Cathal Scott
& Patrick Scott
Cooldorragh,
Ballinahown,
Athlone,
Co. Offaly
N37 V448
(087) 7713845
cathalscott@hotmail.com
Dated: 25th May 2026

Re: Observations on Direct Planning Application by Lemanaghan Wind Farm Activity Company –

Case reference: PAX19.324161

DRAWING TITLE:
**Site Layout Plan Sheet 08 of 10
(1:2,500)**

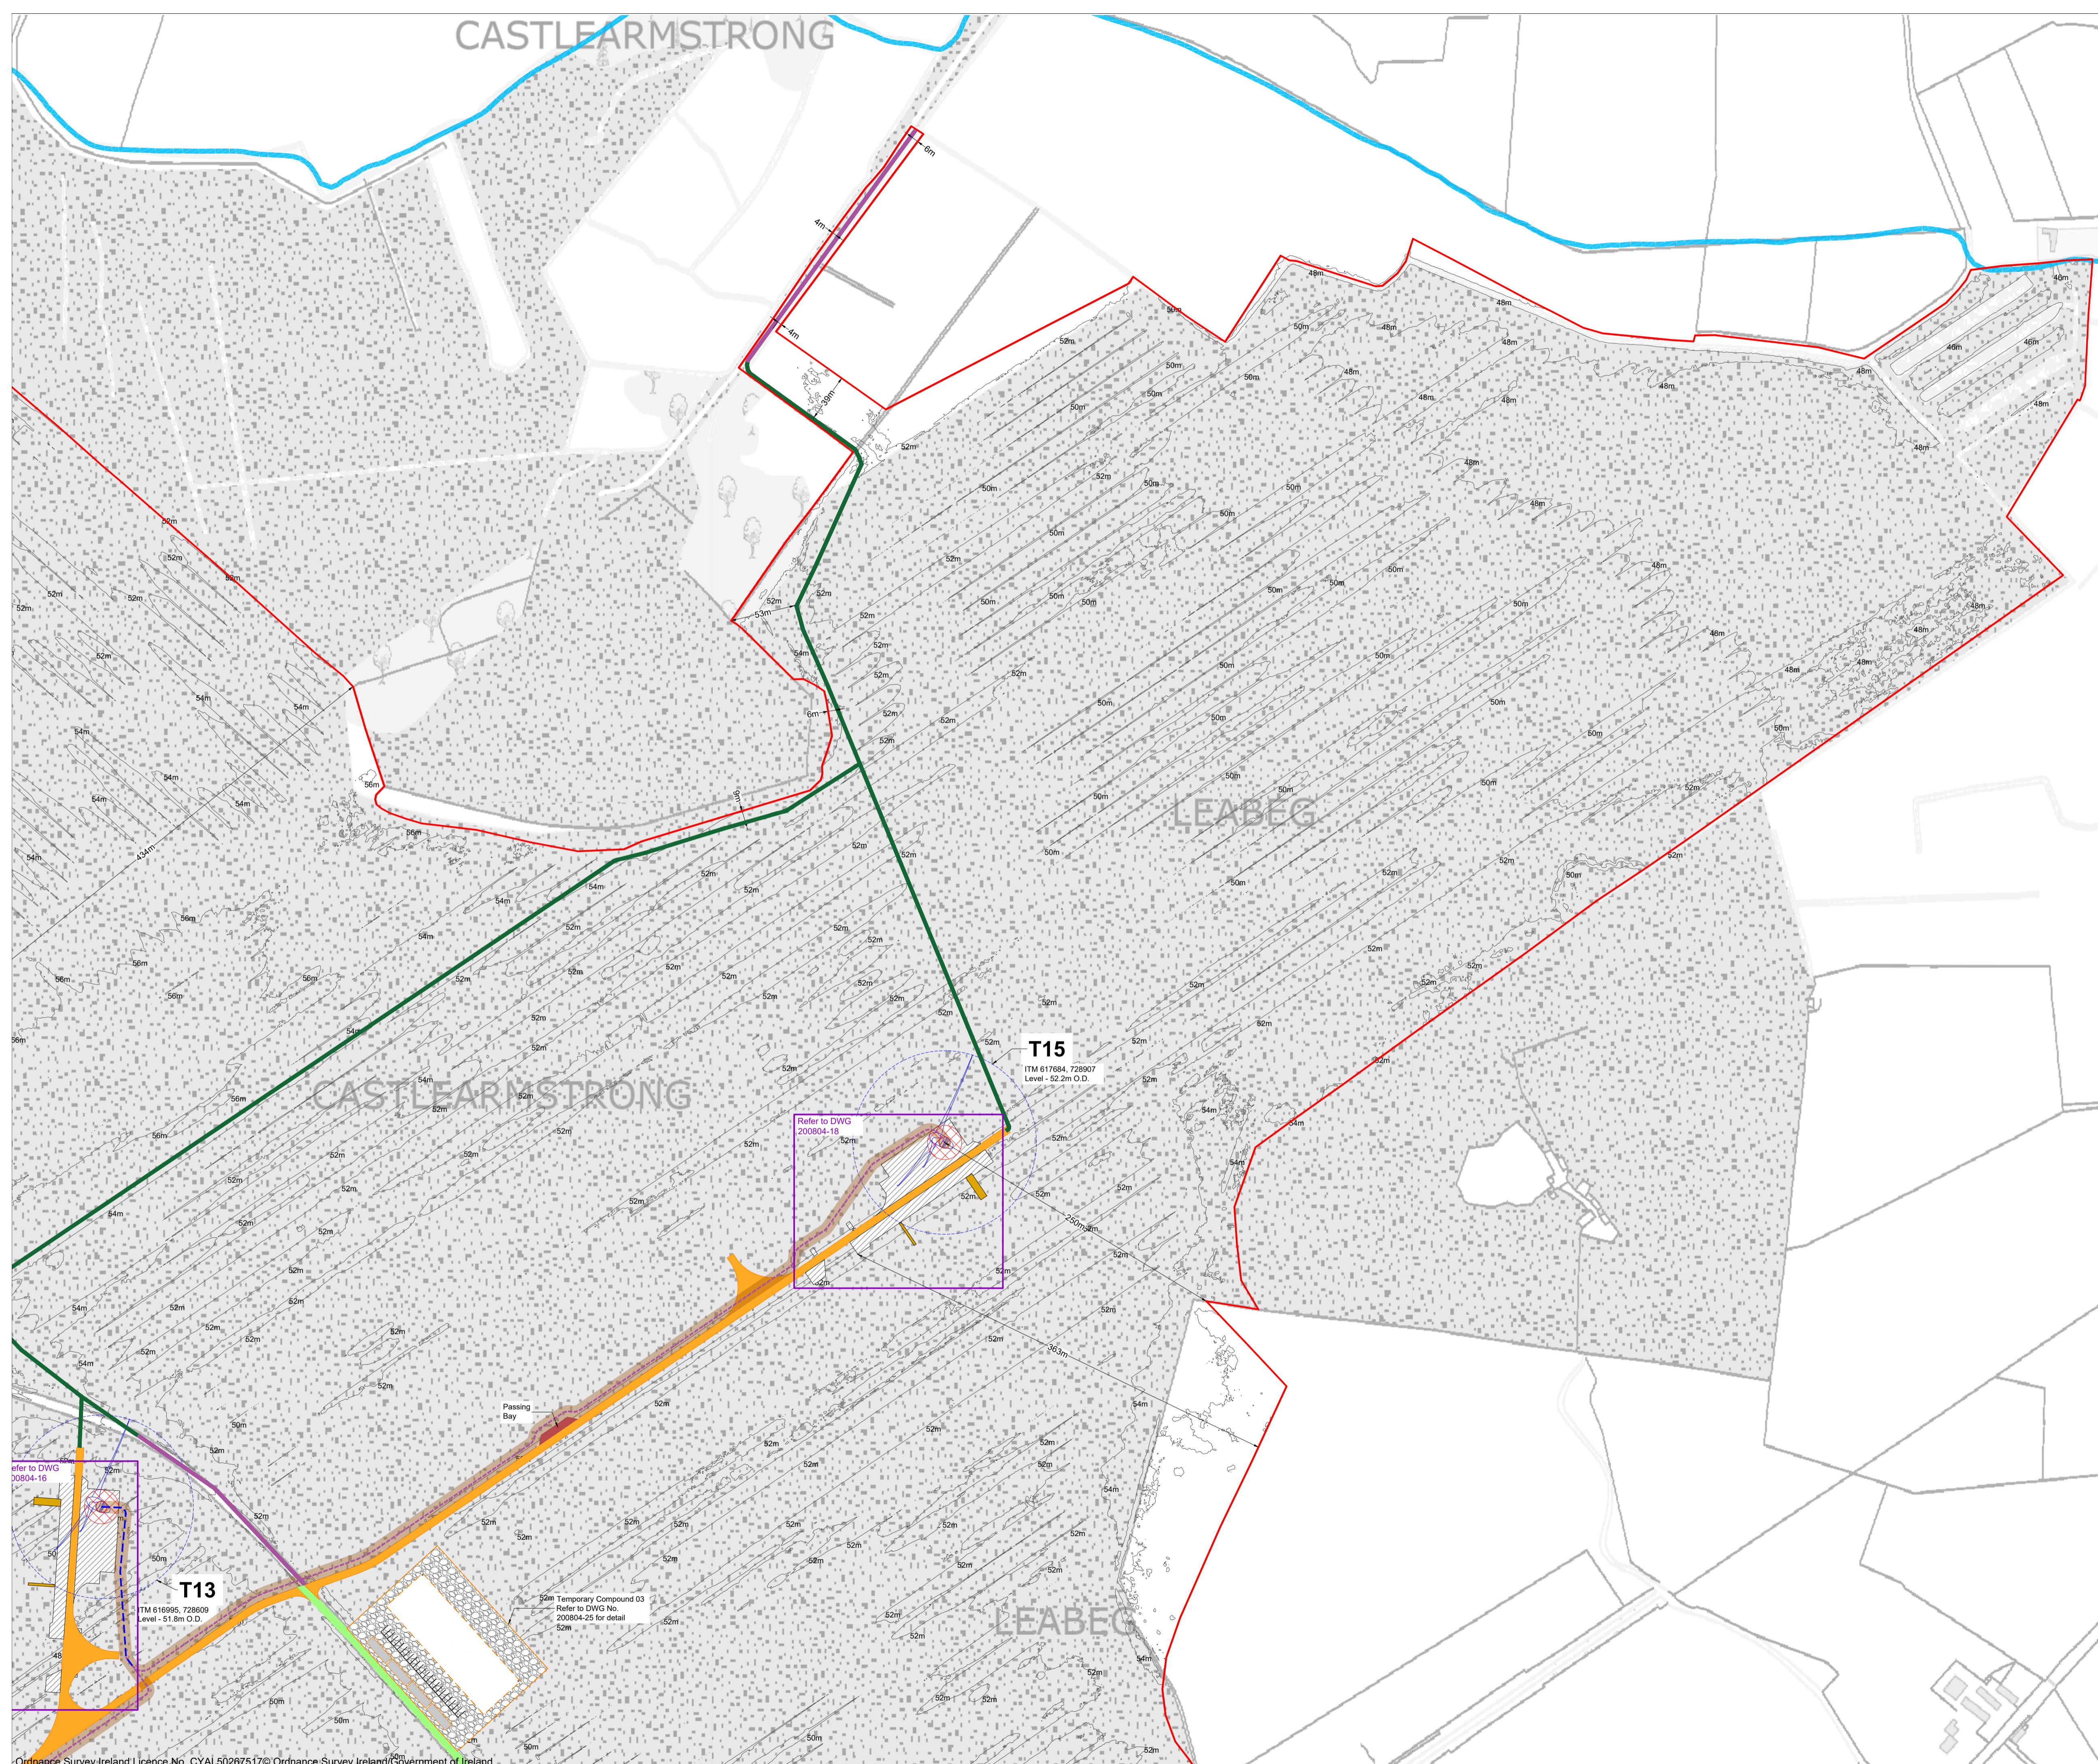
The Site Layout drawings similarly fail to identify the following legal and practical constraints with the Lemanaghan bog:

- turbary plots
- turbary access routes
- areas traditionally used for turf cutting
- lands subject to turbary rights

This omission means the development continues to be presented based on an incomplete description of existing land use and legal interests affecting the site.
